**Re: KENT HOUSE, EAST HARTING, GU31 5LS
REPLACEMENT OF EXISTING GARAGE
SECTION 73 OF THE TOWN AND COUNTRY PLANNING ACT 1990
SUBSTITUTION OF APPROVED SCHEME DRAWING – AMENDMENT TO THE
DESIGN OF THE PROPOSED ROOF**

We refer to the above addressed site and confirm that we are acting on behalf of the owners Mr and Mrs Bonham Carter. Planning permission was granted on 17th May 2023, reference SDNP/23/00648/HOUS.

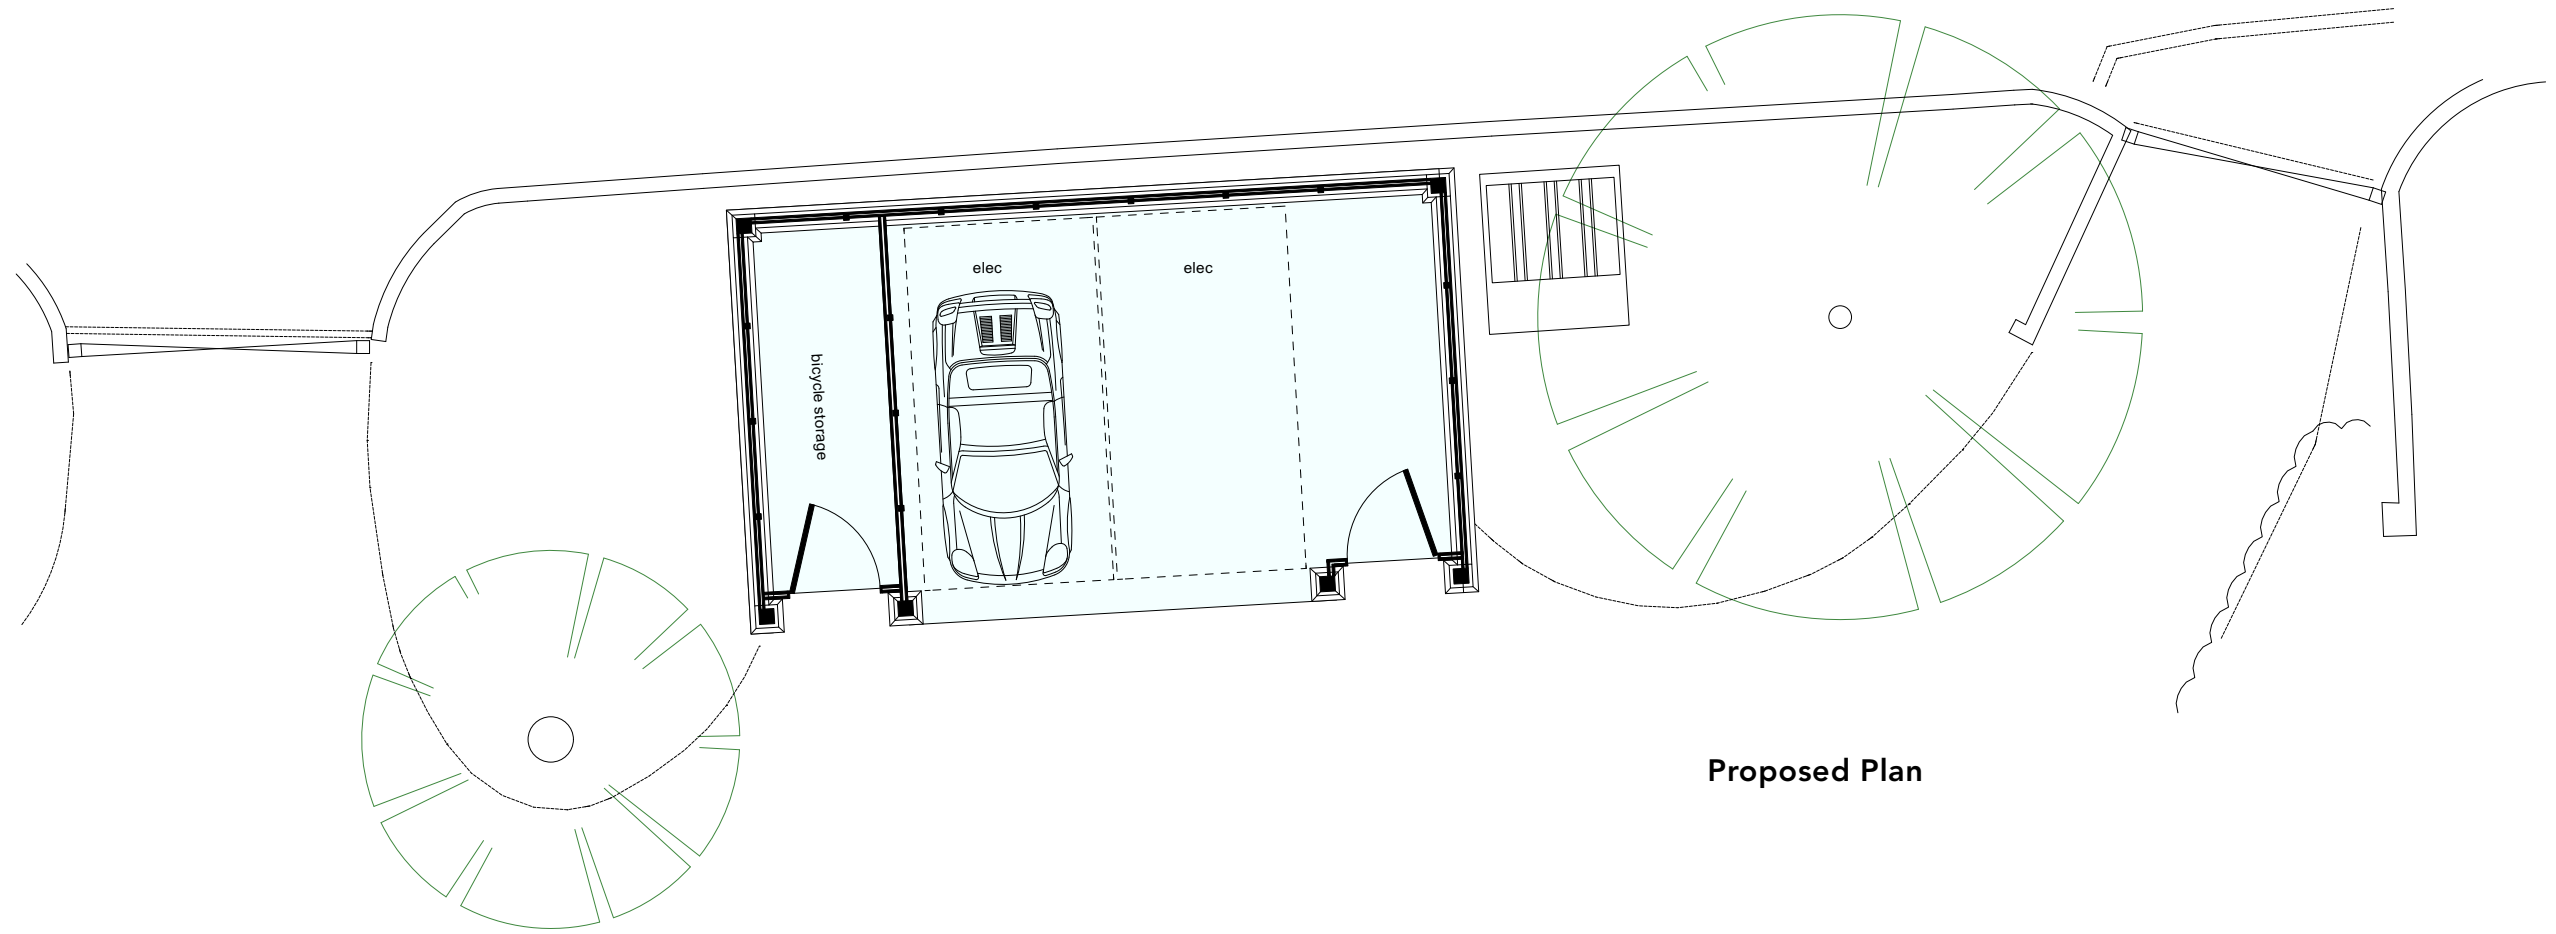
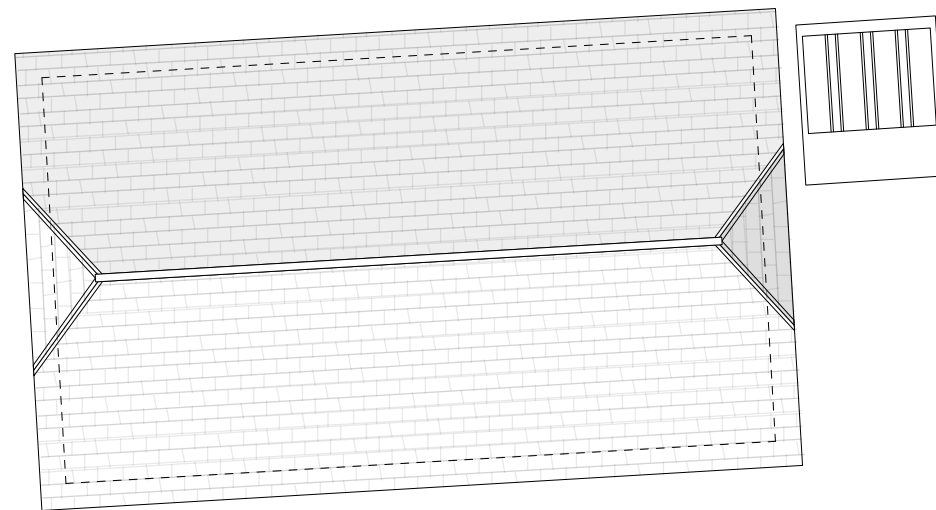
3.3 There is no change to the floor plan of the proposed building nor the ridge height. The proposed elevation is indicated below:

- 3.5 Accordingly, a Variation in a Condition is sought to deal with the proposed amended design of the roof. The approved drawings, 7404/GA/20 C; 7404/GA/19 C and 7404/GA/11 C are proposed to be superseded by amended drawings 7404/GA/20 Rev D; 7404/GA/19 Rev D; 7404/GA/11 Rev D, to reflect the revised scheme drawing as a variation of Condition 2. Drawing 7404/GA Rev D also provides examples of barn hip roofs, as now proposed, in the immediate vicinity. It is argued that the proposed roof would therefore be wholly appropriate and in context in this location, reflecting the form of roofs within the wider site.

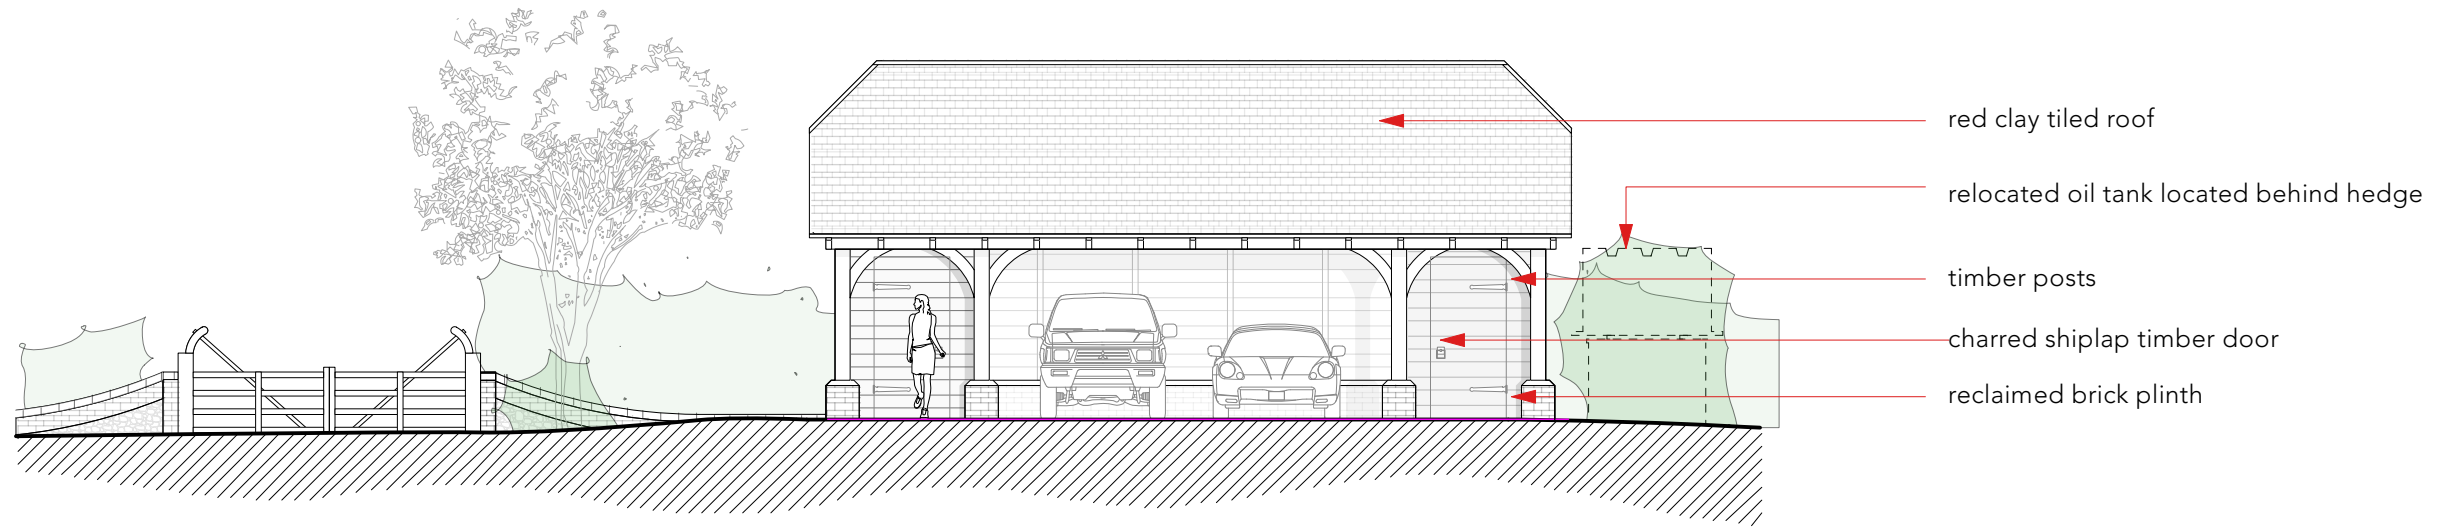
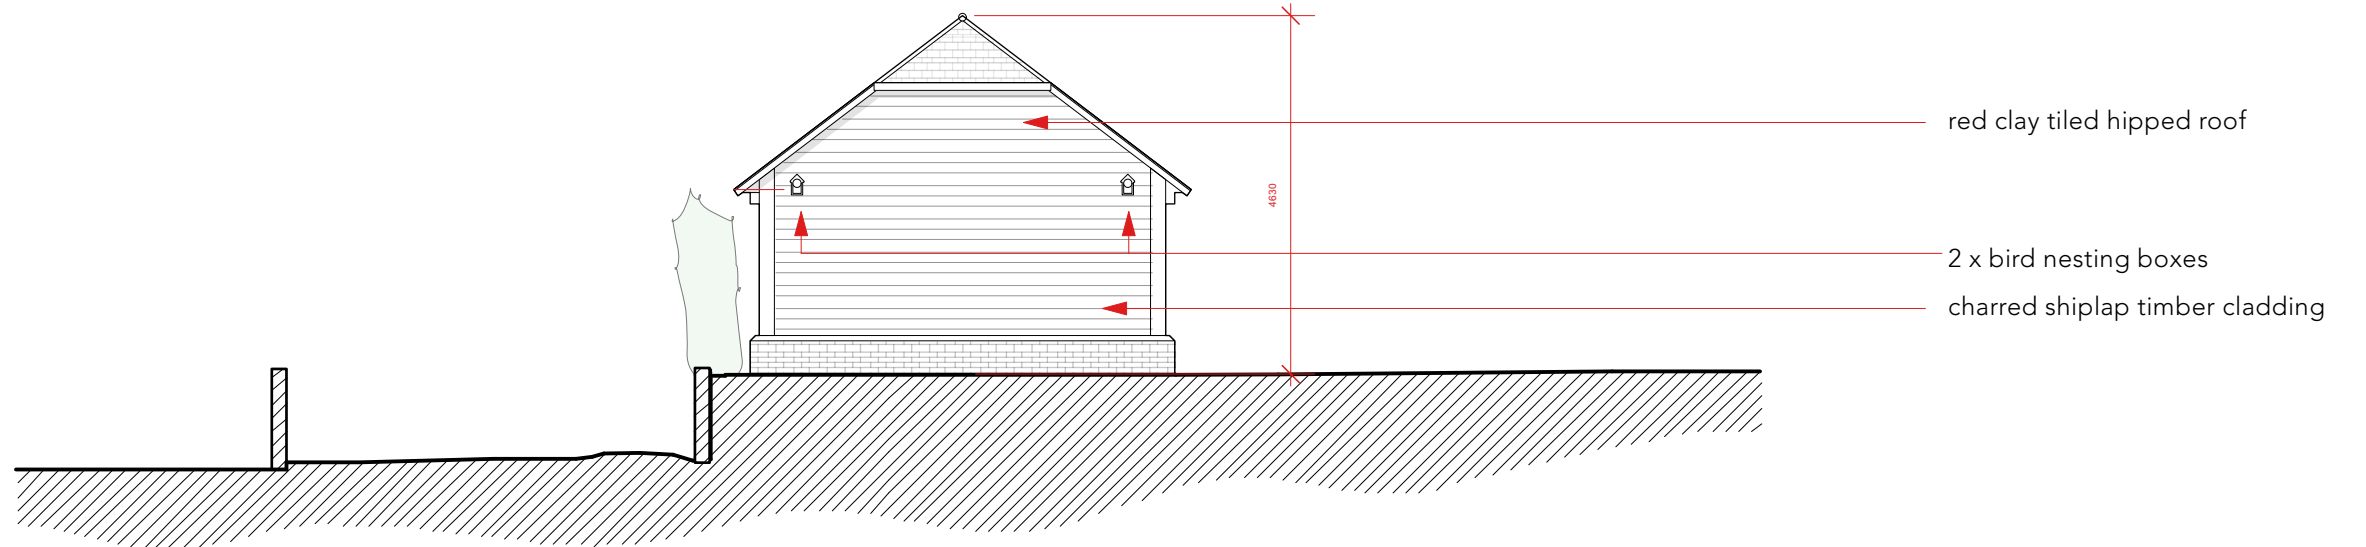
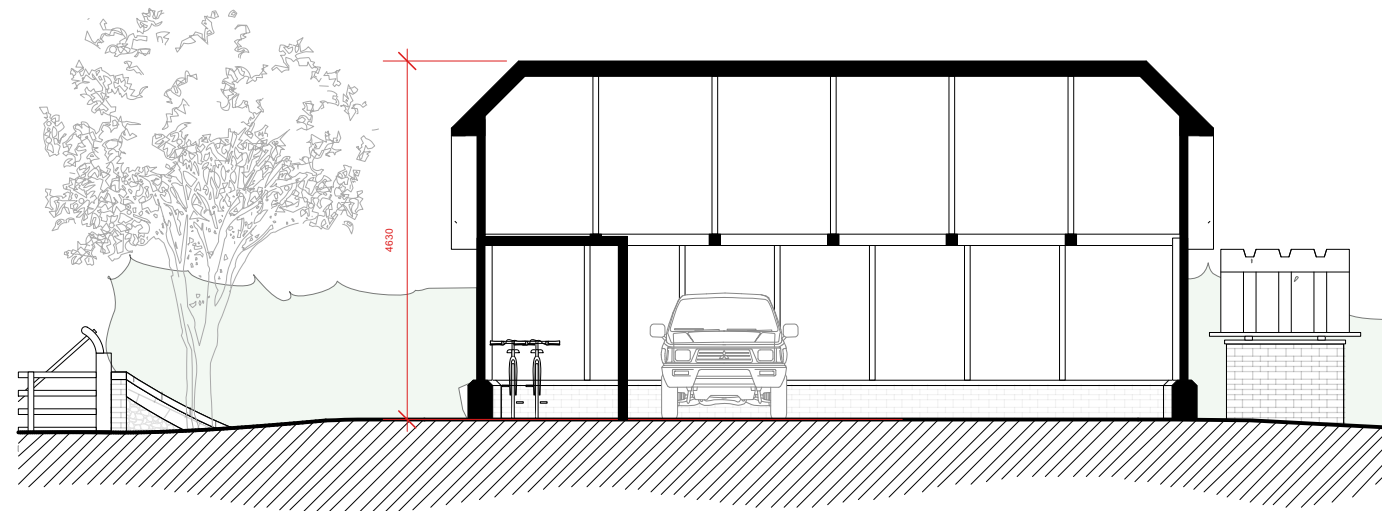
- 2.4 This proposal would be in the same position as the approved building and only seeks to alter the shape of the proposed roof. Materially however, the proposal would not alter the layout or the floor area, and would retain the approved ridge height. The eaves would be 100mm lower. It simply seeks to alter the end elevations of the roof from a gablet to a 'barn hip'. Whilst the proposed roof would be marginally larger than that previously approved, it would be more in keeping with the existing roof forms in the vicinity and in particular the existing outbuildings on the site.

3.2 Since permission was granted however the applicant has reconsidered the proposed design and seeks permission to vary the design of the roof from a gablet to a barn hip roof. The approved elevation is indicated below.
